From: Chris Cruse <chris@cruseandassoc.com>
Sent: Thursday, September 5, 2024 8:00 AM
To: Bradley Gasawski; rik.lewis@yahoo.com
Cc: Jamey Ayling; Chace Pedersen; Zach Torrance-Smith
Subject: RE: SP-24-00011 Lewis - Transmittal of Comments

LEWIS SHORT PLAT PART OF SECTION 29, T. 17 N., R. 20 E., W.M. KITITAS COUNTY, WASHINGTON

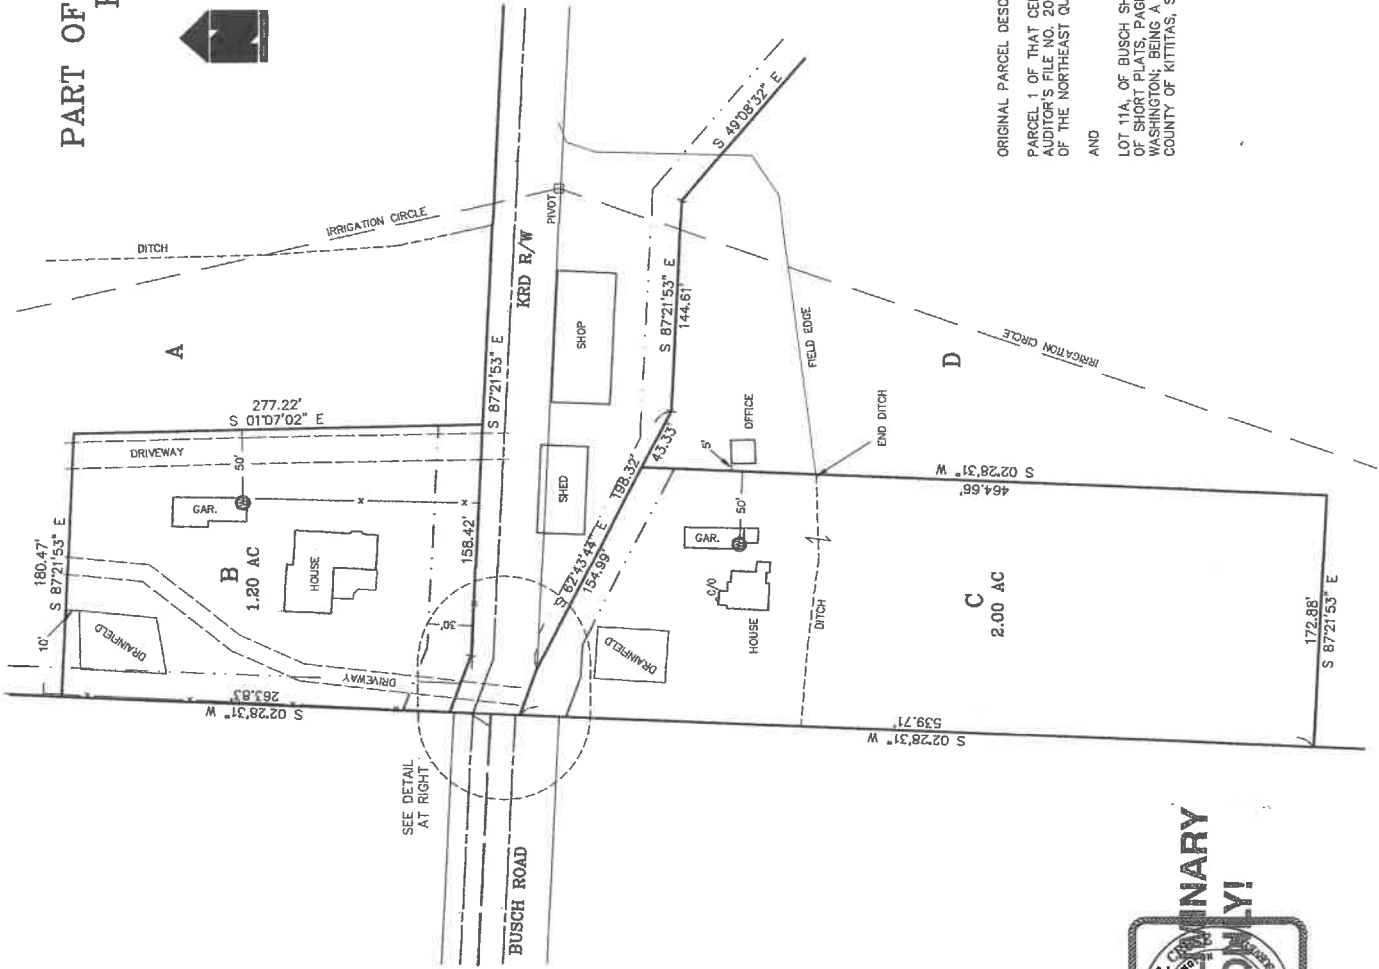
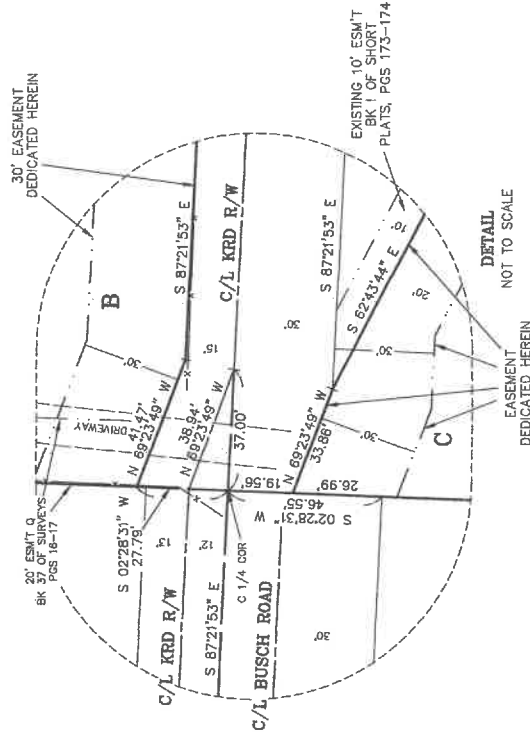
We submitted a letter to the file to address the PW survey comment 1 in regards to the topographic elements and will update mapping for final to address both survey comments 1 and 3. PW survey comment 2 about KCC 17.29.090 is not relevant as KCC 16.12.040 that allows for these homes to be split off has a clause in code that allows for the new lots to have dimensions less than required by the AG-20 zoning.
